Your ref:	1 West Halkin Street - Condit...	Please reply to:	Rayhan Ali
Our ref:	23/07524/ADLBC	Tel No:	07866033247
		Fee Queries:	0207 641 6500;
		Email:	planningreception@westminster.gov.uk;
Mr Jonathan Gray Grays Surveying Services Ltd 27 Upper Weybourne Lane Farnham GU9 9DG United Kingdom		Incomplete Applications Town Planning & Building Control City of Westminster PO Box 732 Redhill, RH1 9FL	
		9 November 2023

Address: 1 West Halkin Street, London, SW1X 8JJ,

Proposal: Details of the Photographic method statement relating to repairs of ceilings, cornices, skirtings and floorboards. Detailed drawings showing the following alteration to the scheme. Pursuant to Condition 4 and 7 of Listed Building consent dated 27 September 2023(RN: 23/03593/LBC)

Ground Floor -
Floor Build Ups **UFH Omitted**

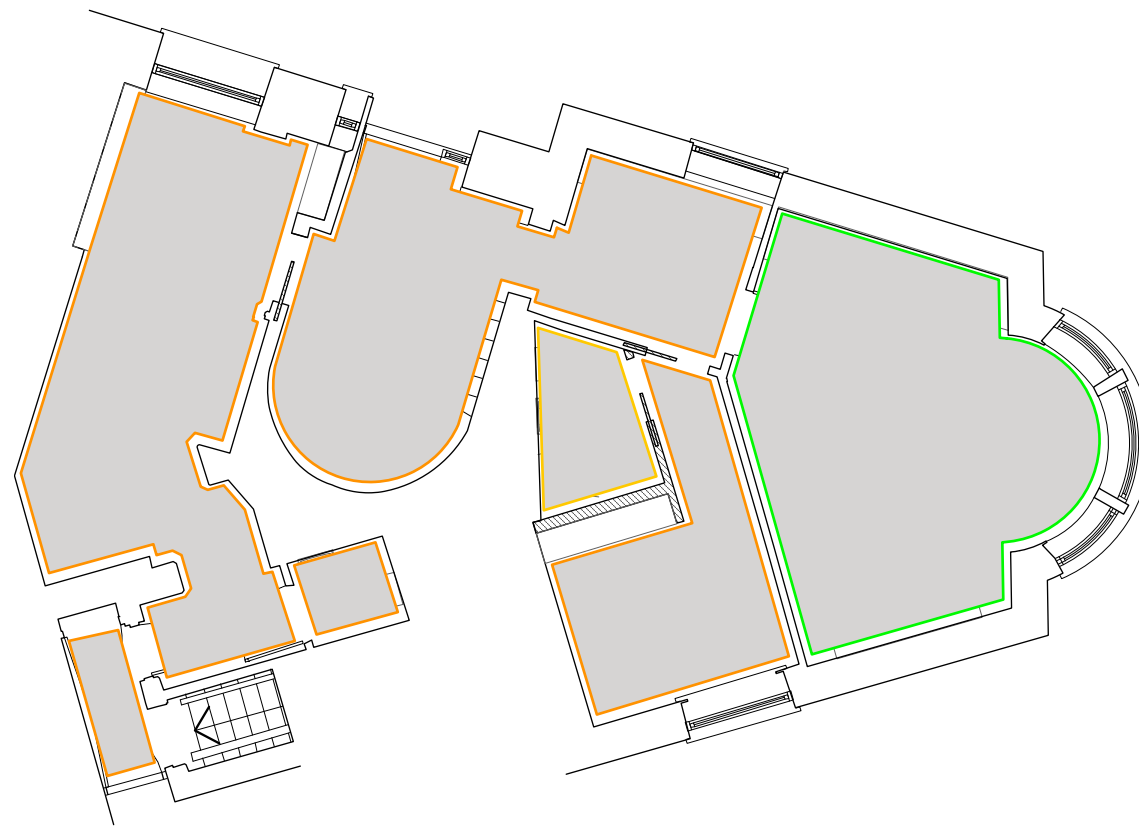
- 3 Please note that in relation to Condition 7-part c, we need typical sections showing

relationship of new floor finishes with existing historic floorboards/structure, including showing the build-up required for what appears to be underfloor heating? Please also confirm where underfloor heating is shown as proposed in consented plans as we cannot see that we have approved this under approved plan nos. in consent 23/03593/LBC. If underfloor heating was not approved, please omit that element from the drawings, you will need to apply for a separate listed building consent.

Drawing Title
SF Master Wardrobe Detail 1

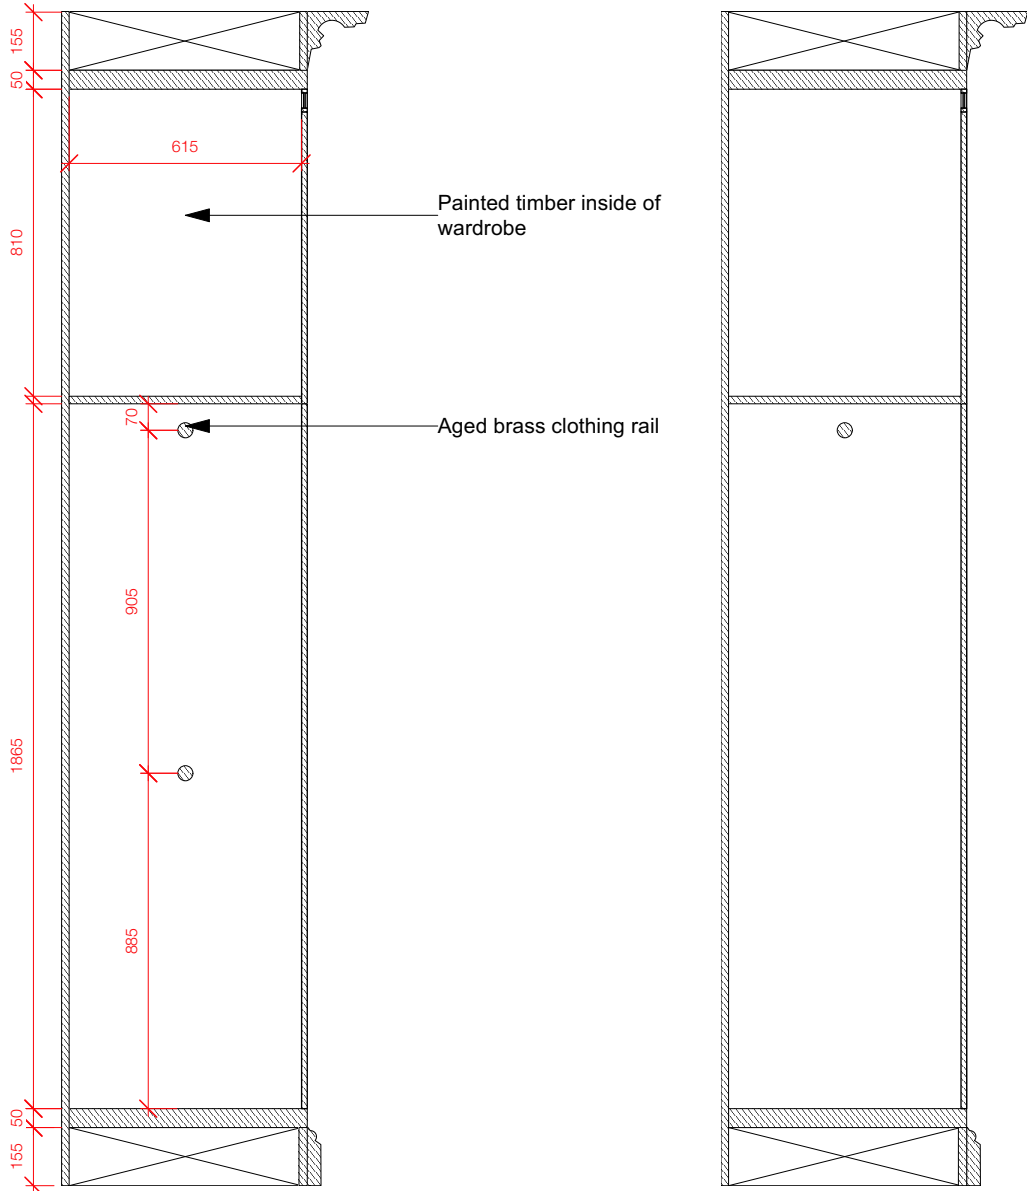
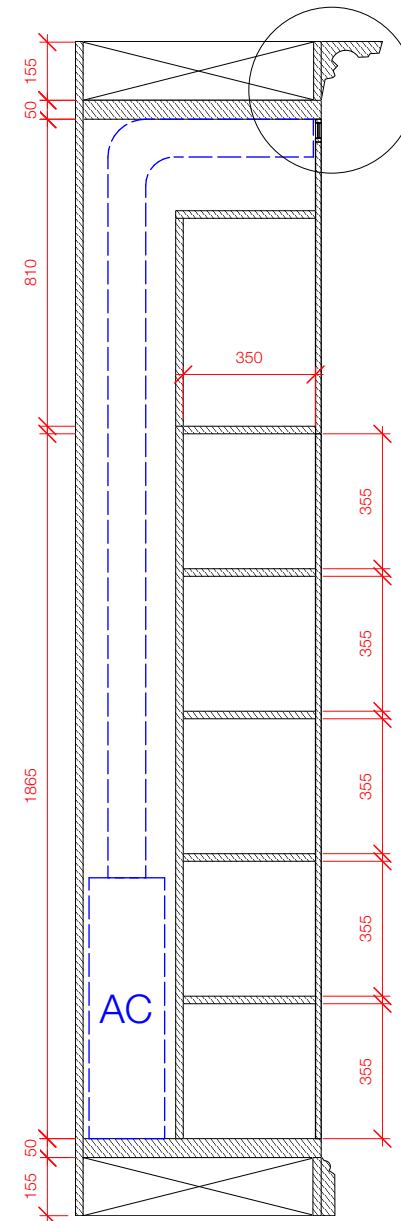
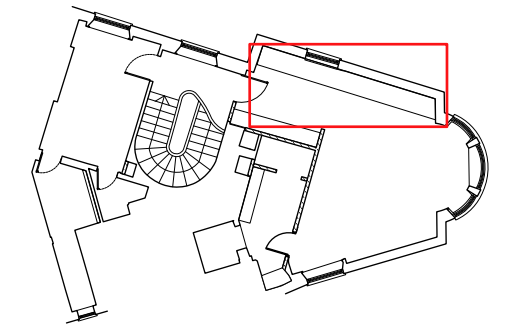
- 1 Details in relation to part d of Condition 4 need to be provided. You will need to provide details of the floor-fixed furniture which will house the internal air conditioning cassettes. Otherwise please confirm that you want to discharge only part of Condition 4 (a, b, c, and f) and details in relation to part d will be discharged later?

Ground Floor RCP & Wall Lights

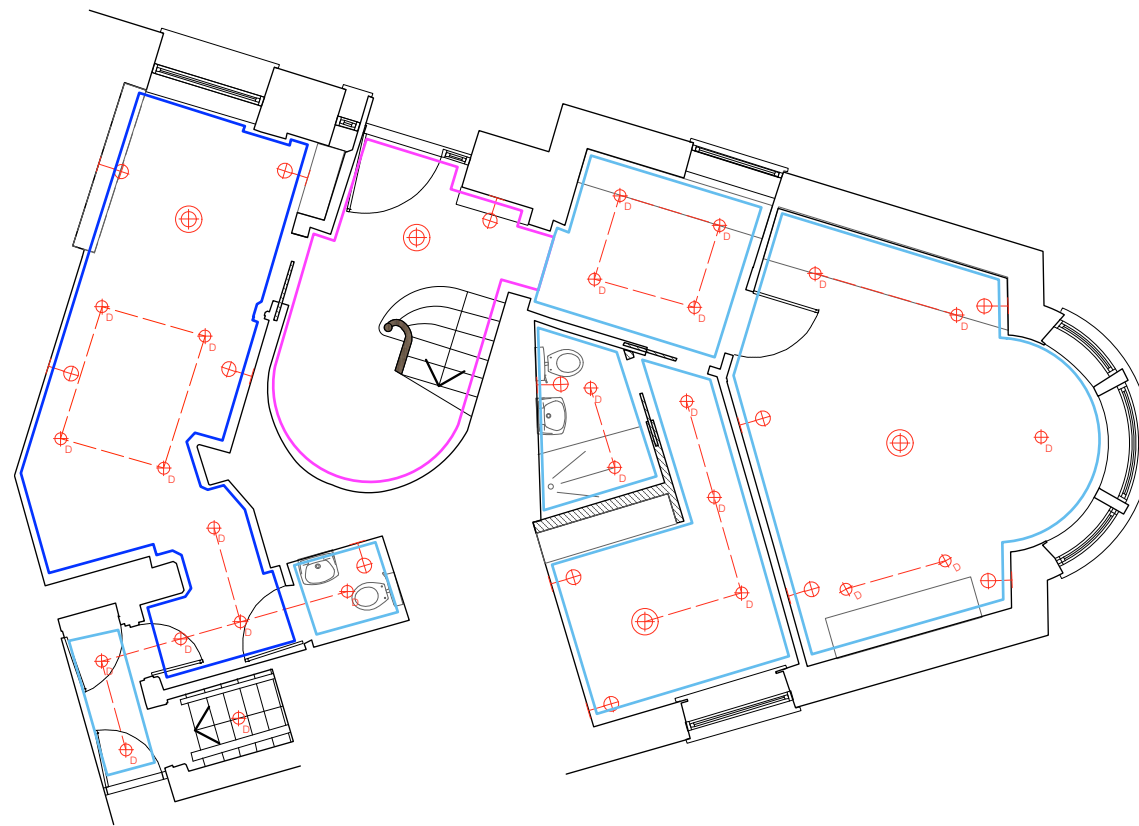
- 2 Please note that in relation to Condition 7-part b, details of downlighting, speakers and other inset ceiling fixed equipment are not acceptable in any original ceilings and should be avoided entirely at principal (i.e., ground and first) floor levels. The RCP drawings of the ground and first floor levels need revising to omit downlighting at these levels. We also need typical sections showing relationship of new ceilings with existing historic ceilings/structure.
